MT OWEN / GLENDELL

1st August 2019

**Subject: Glendell Mine (DA 80/952) Modification 4 – Response to Submissions Report
Recommendations from Biodiversity and Conservation Division (BCD)**

Offset Strategy Plan

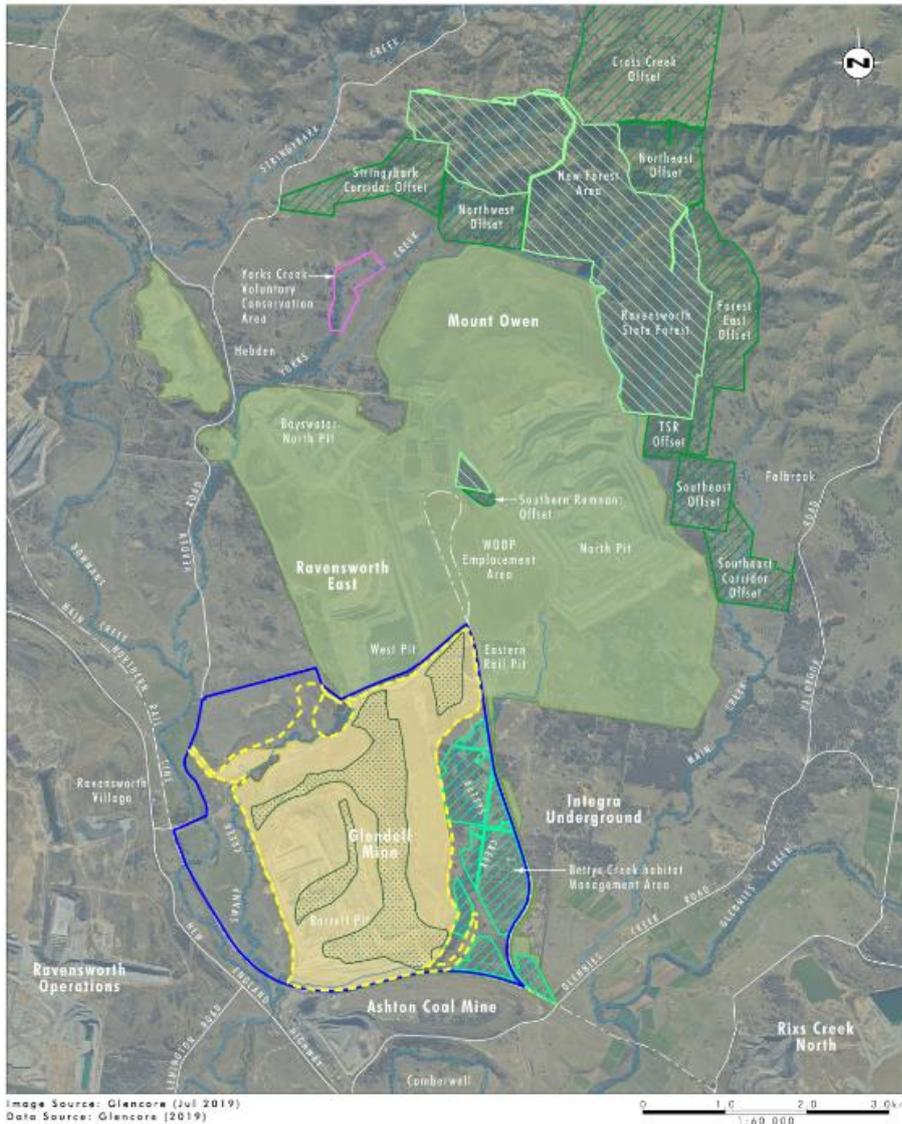
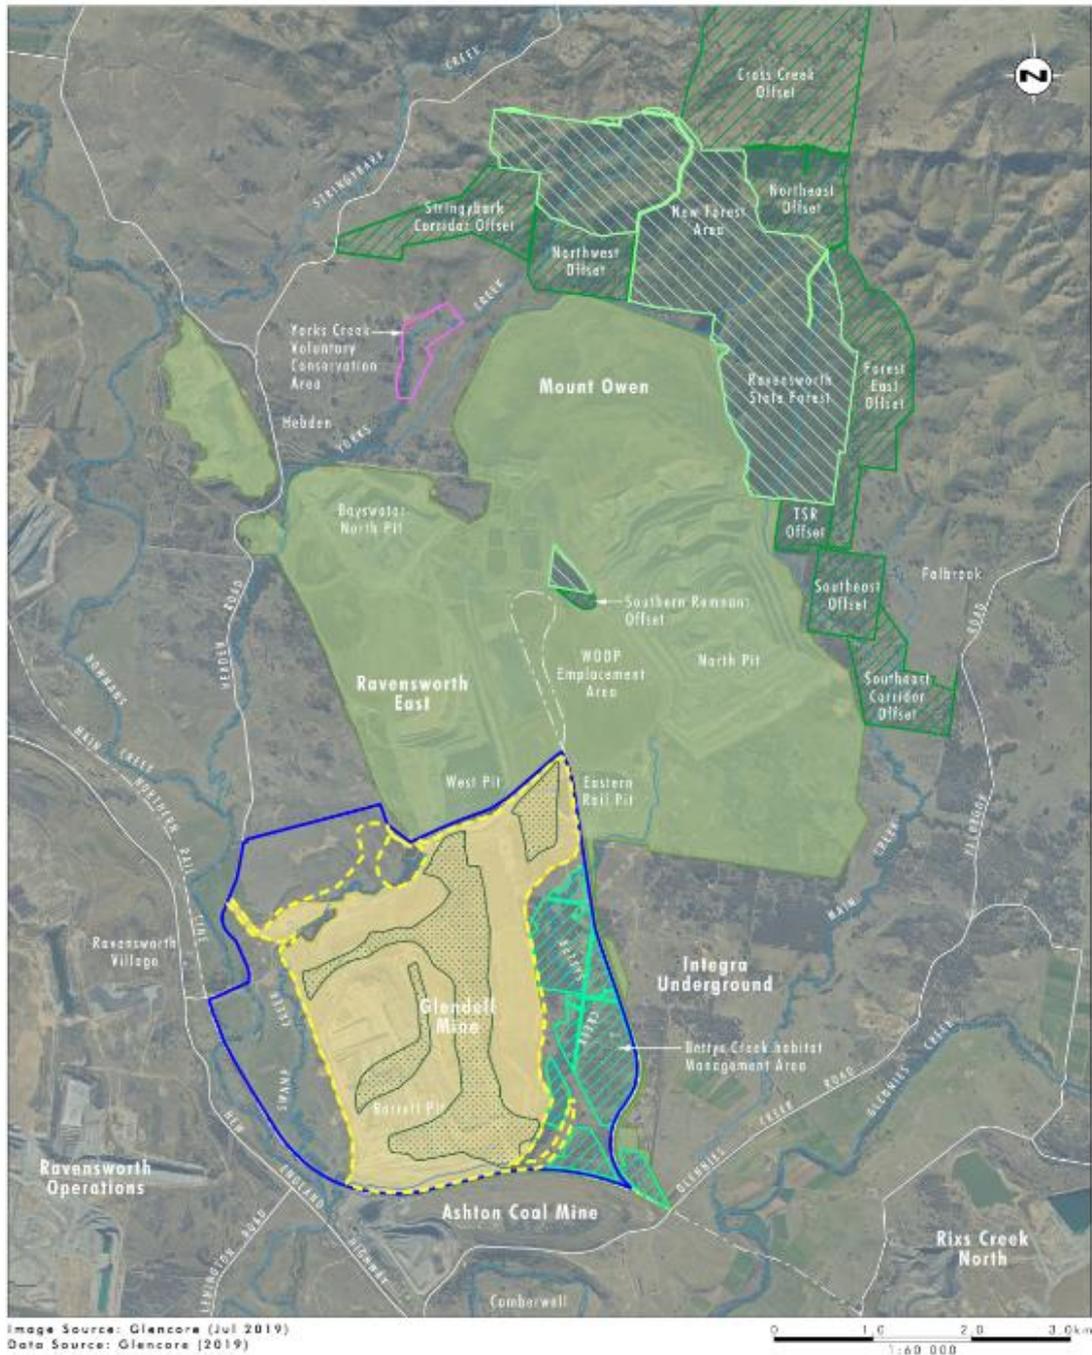
7. BCD recommend that the 'Offset Strategy Plan' in Appendix 5 of any updated version of the Glendell Mine consolidated consent includes the Southern Remnant and Southern Remnant Offset.

- An updated Offset Strategy Plan will be provided to DPIE with the response to the Glendell MOD 4 draft conditions, for inclusion in the final consolidated consent.
